July 17, 2024

Colleen Ruiz, PE
Stantec
733 Marquette Ave, Suite 1000
Minneapolis MN 55402

**Re: Westpointe Data Center at 8401 Daytona Rd. NW
Erosion and Sediment Control Plan
Engineer's Stamp Date - missing (H09E001B)**

SHEET NO. ESC - 002

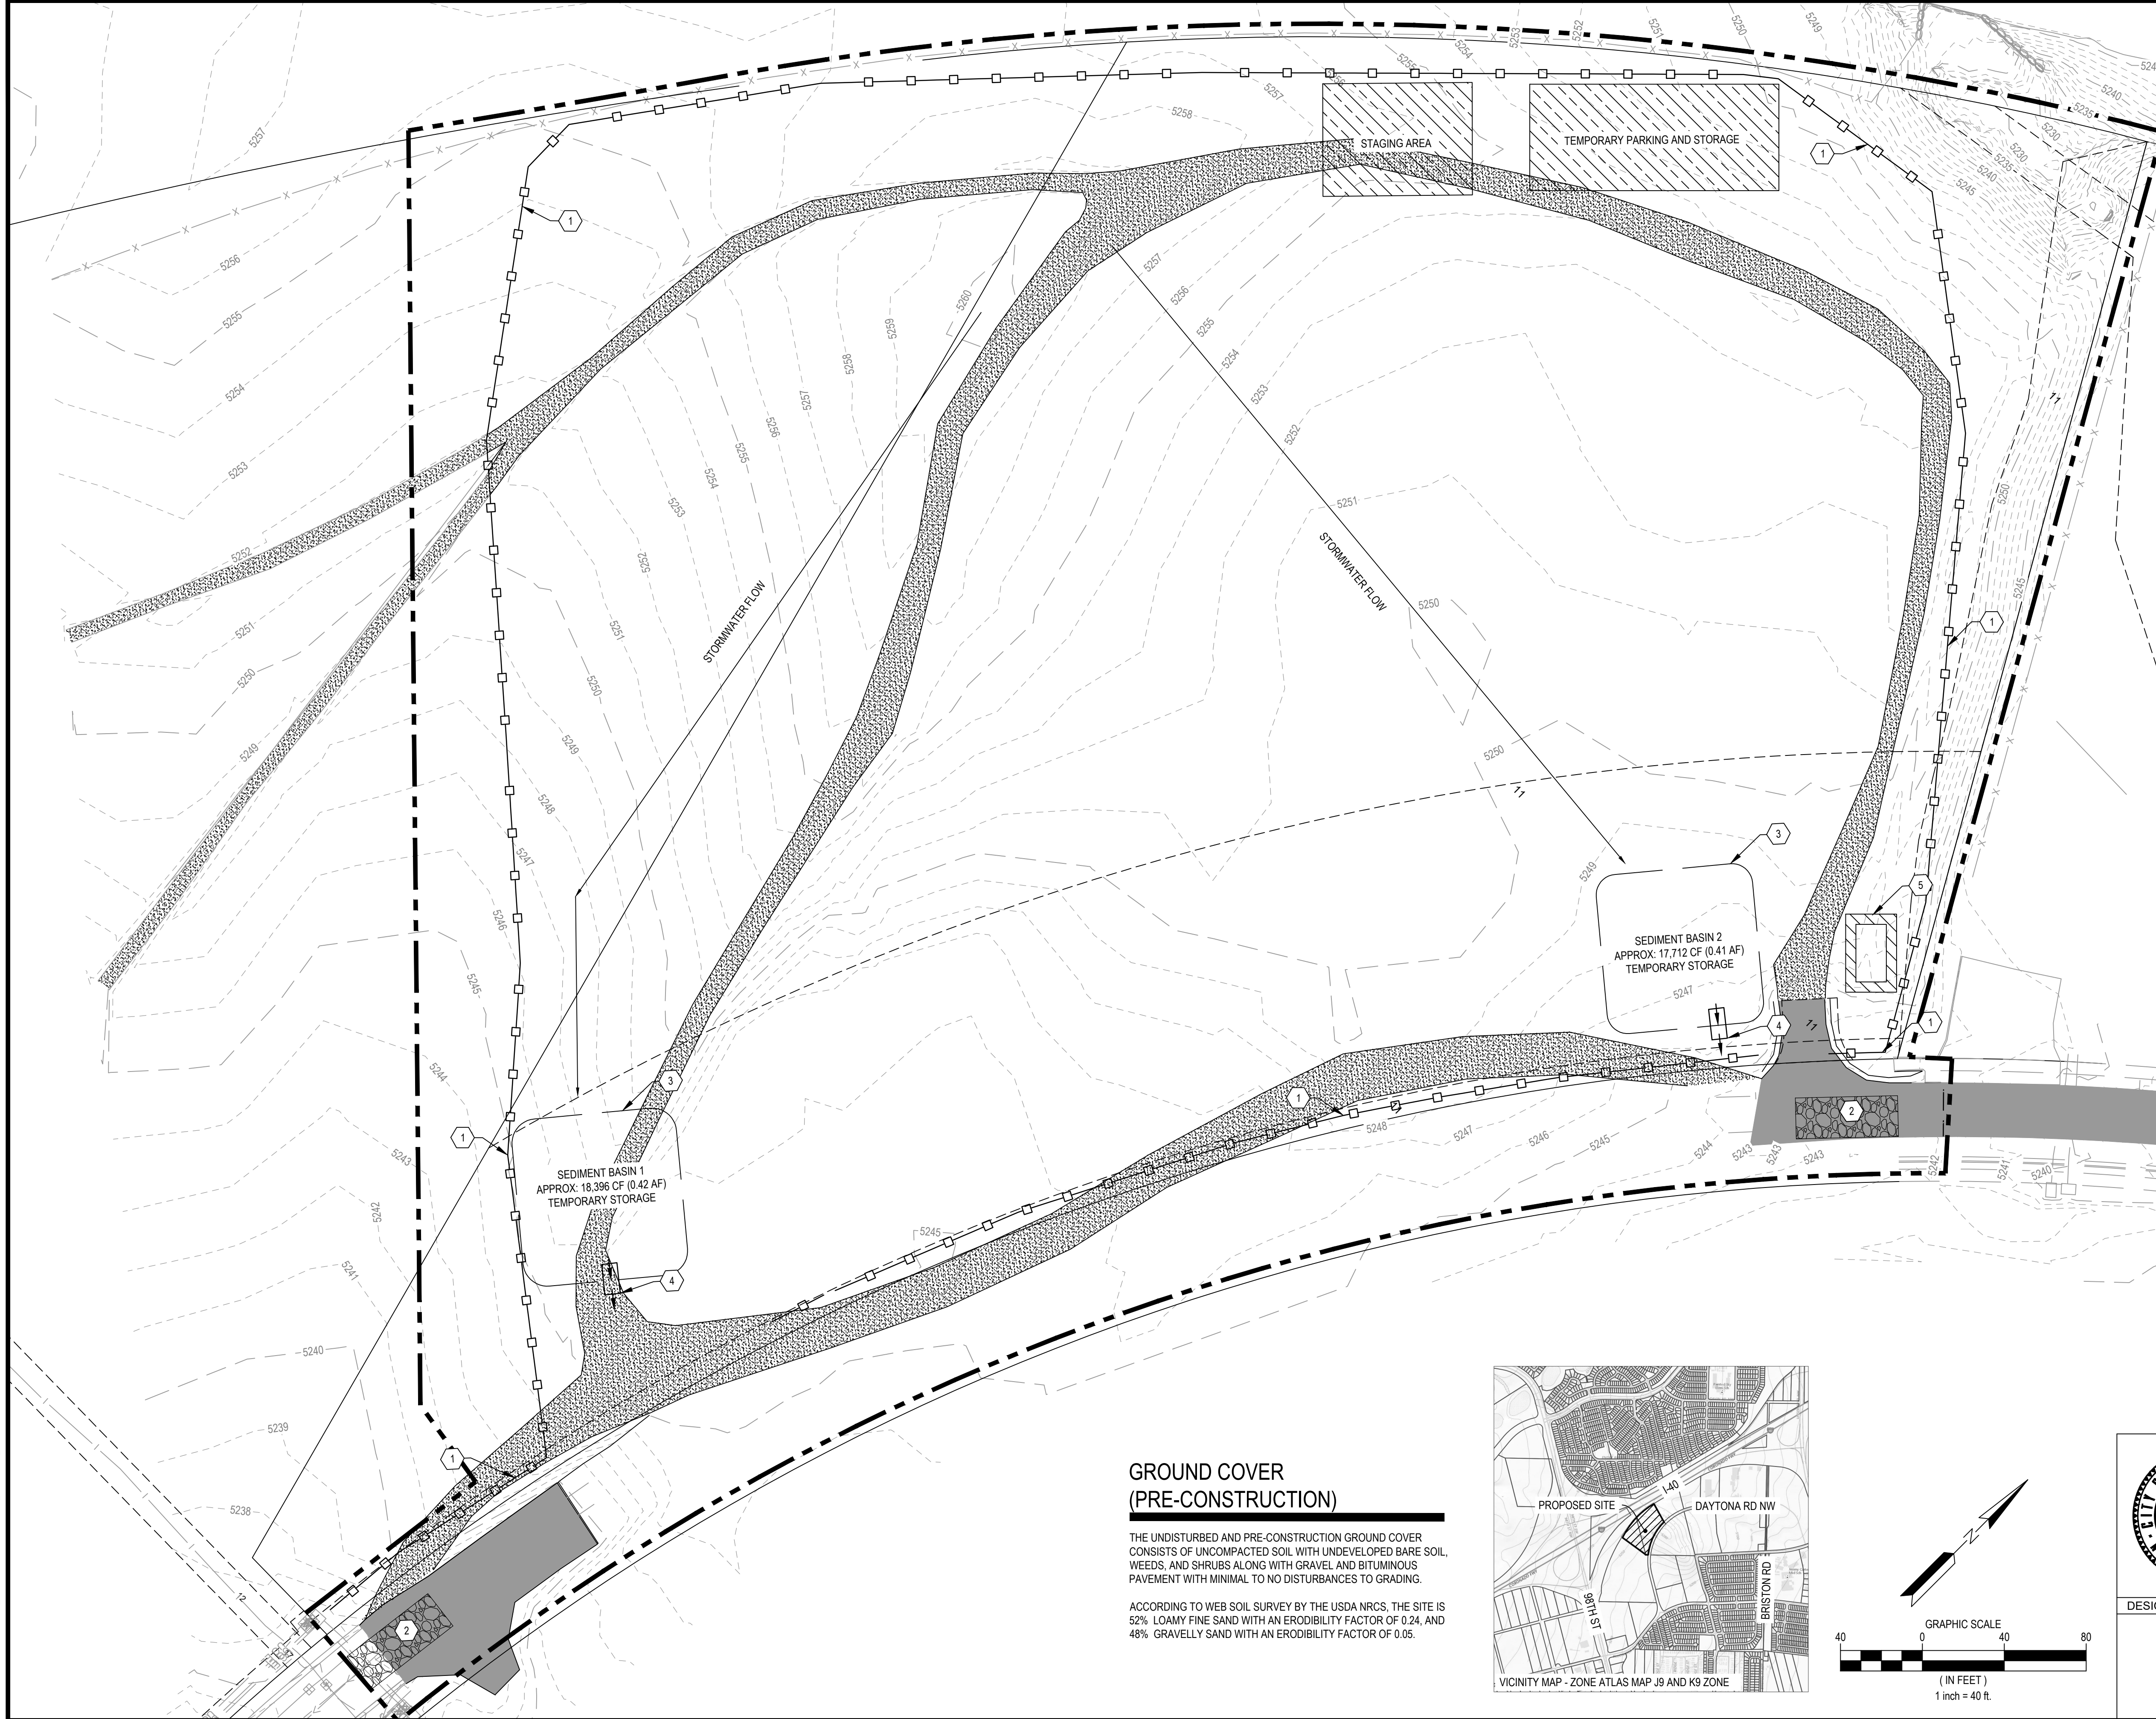
4. Wash water from concrete, paint, and stucco must be directed into a leak-proof container per CGP 2.3.4. Correct general erosion note #6 on sheet ESC-002 and Keyed note #5 on ESC-003 accordingly.

SHEET NO. ESC - 003

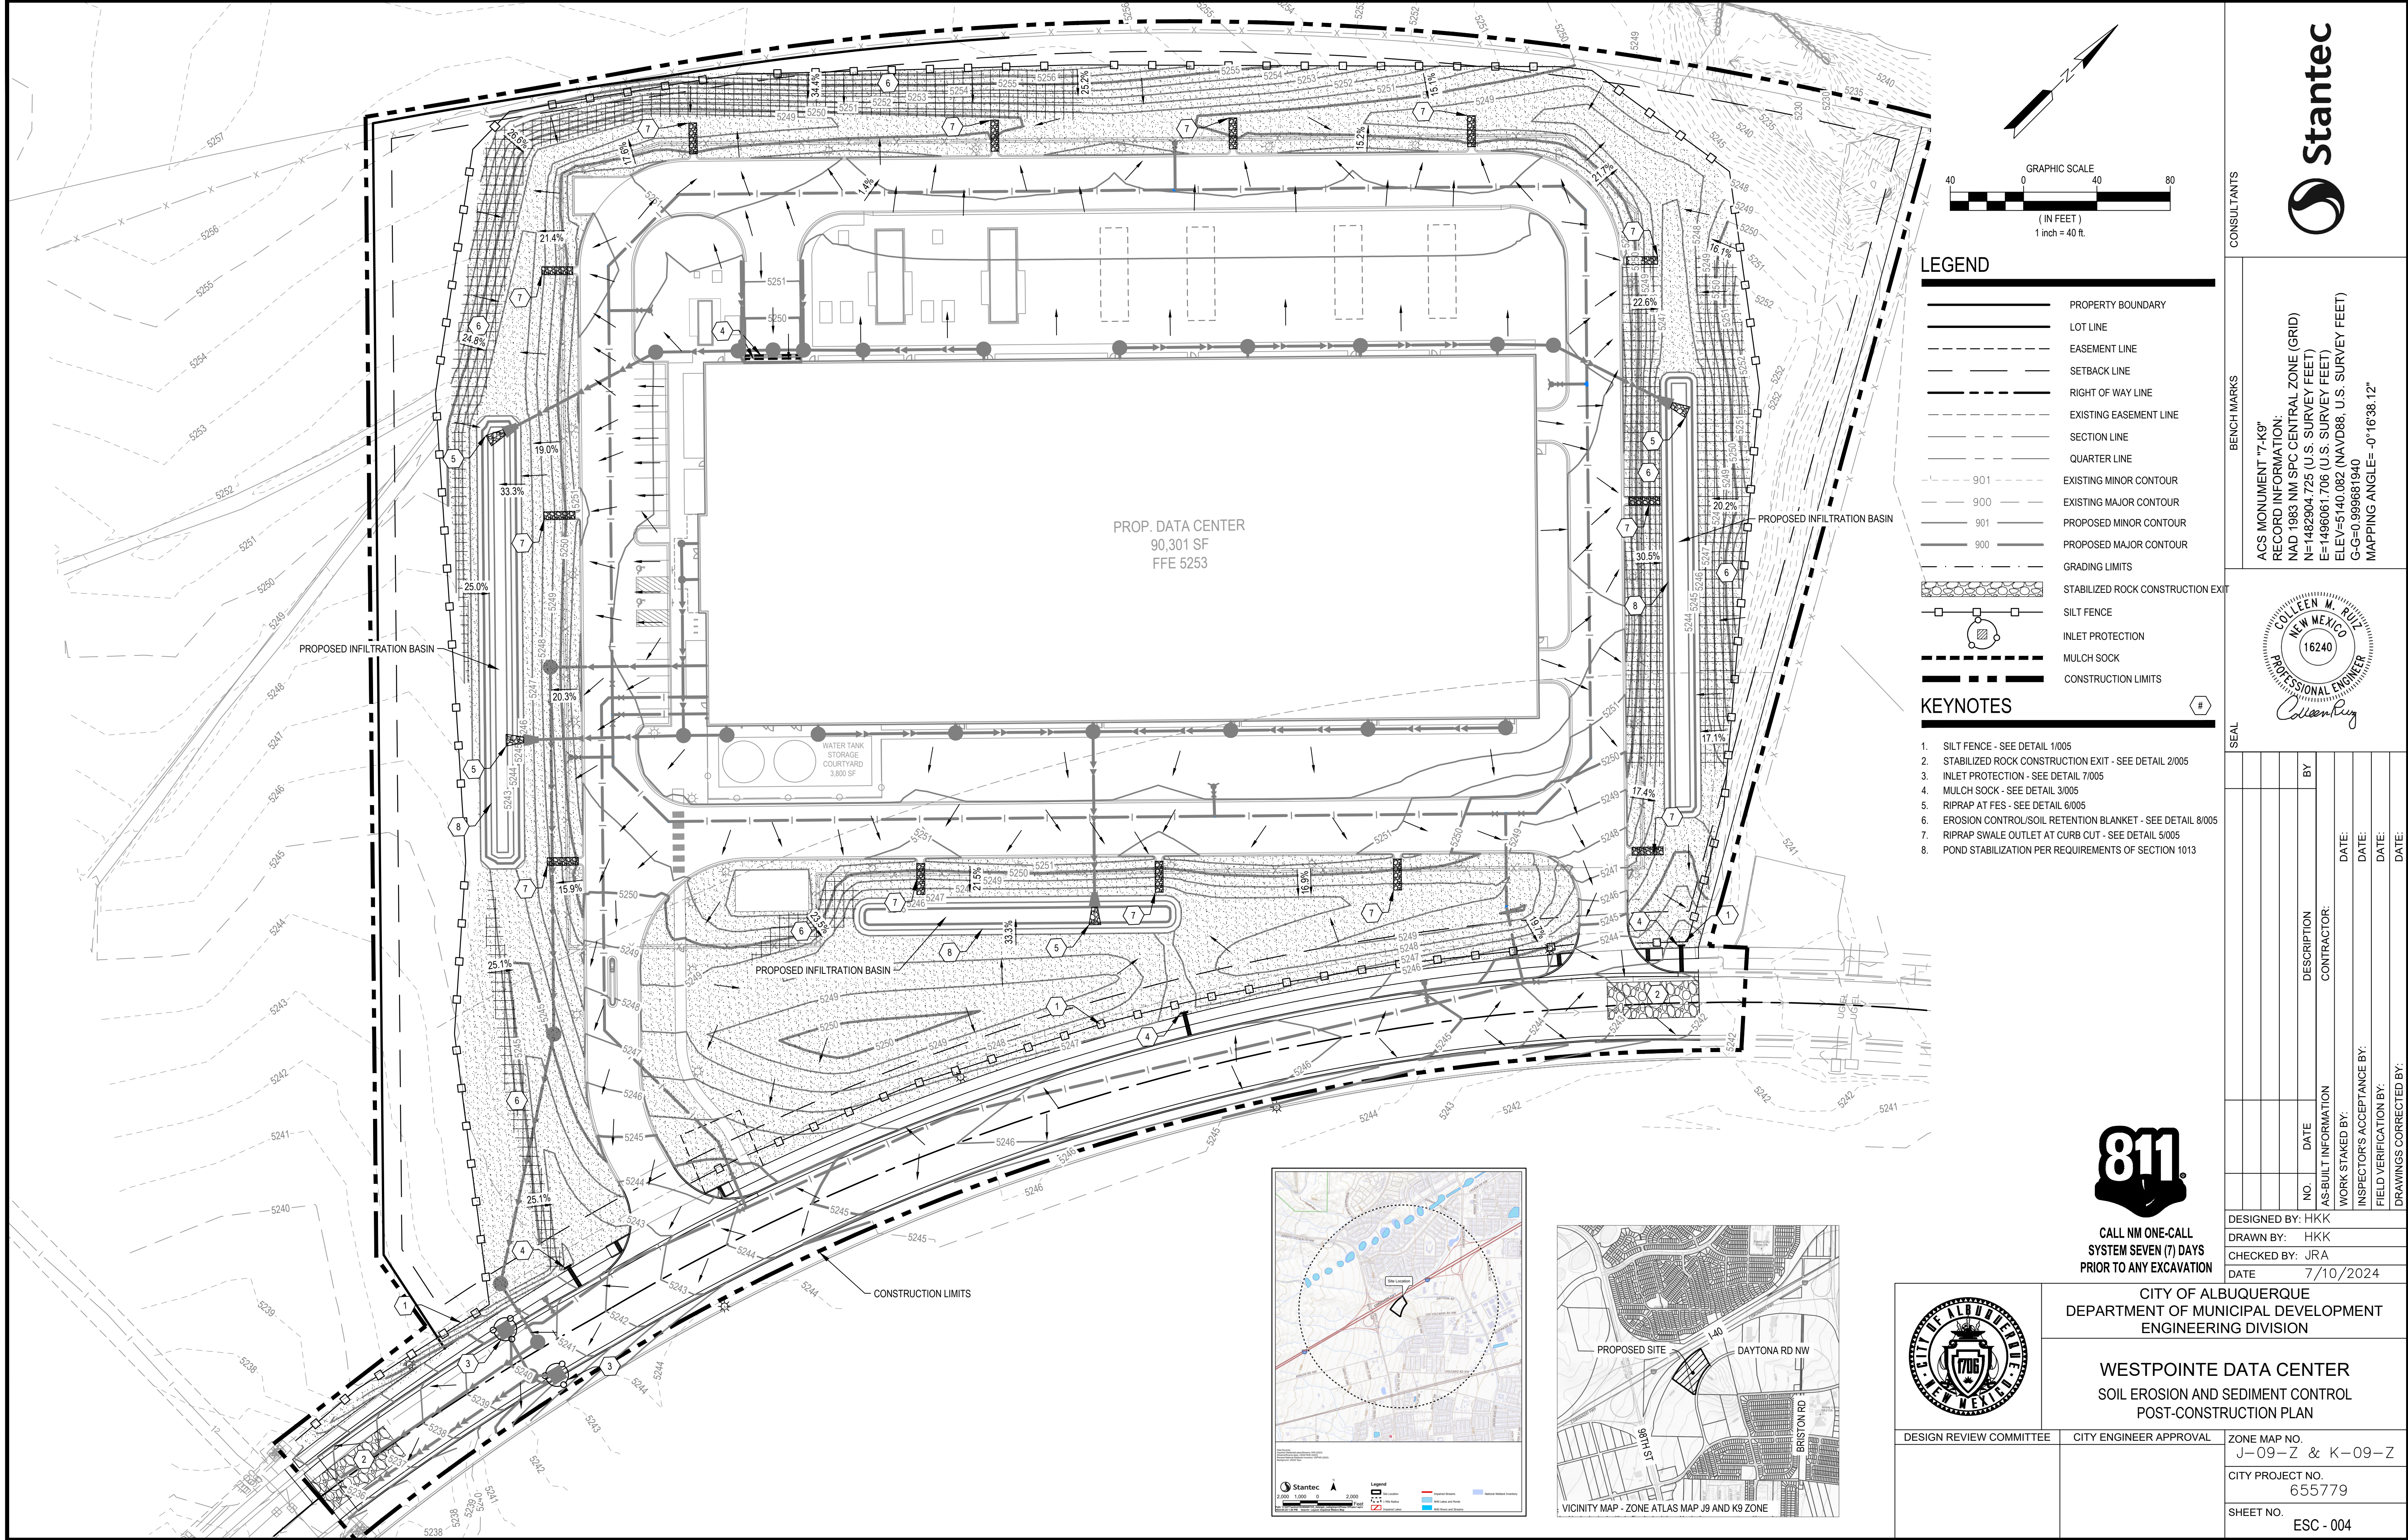
3. Temporary sediment basins and sediment traps are required for this site since it exceeds 5 acres. The design volumes satisfy CGP 2.2.12, but dimensions (L, W, and D) and elevations are missing and must be specified for both ponds. Also, specify the overflow inverts, dimensions, and material. Include volume and hydraulic design calculations, construction specifications, maintenance schedules, and inspection criteria, per CGP 9.6.1(C)(i).
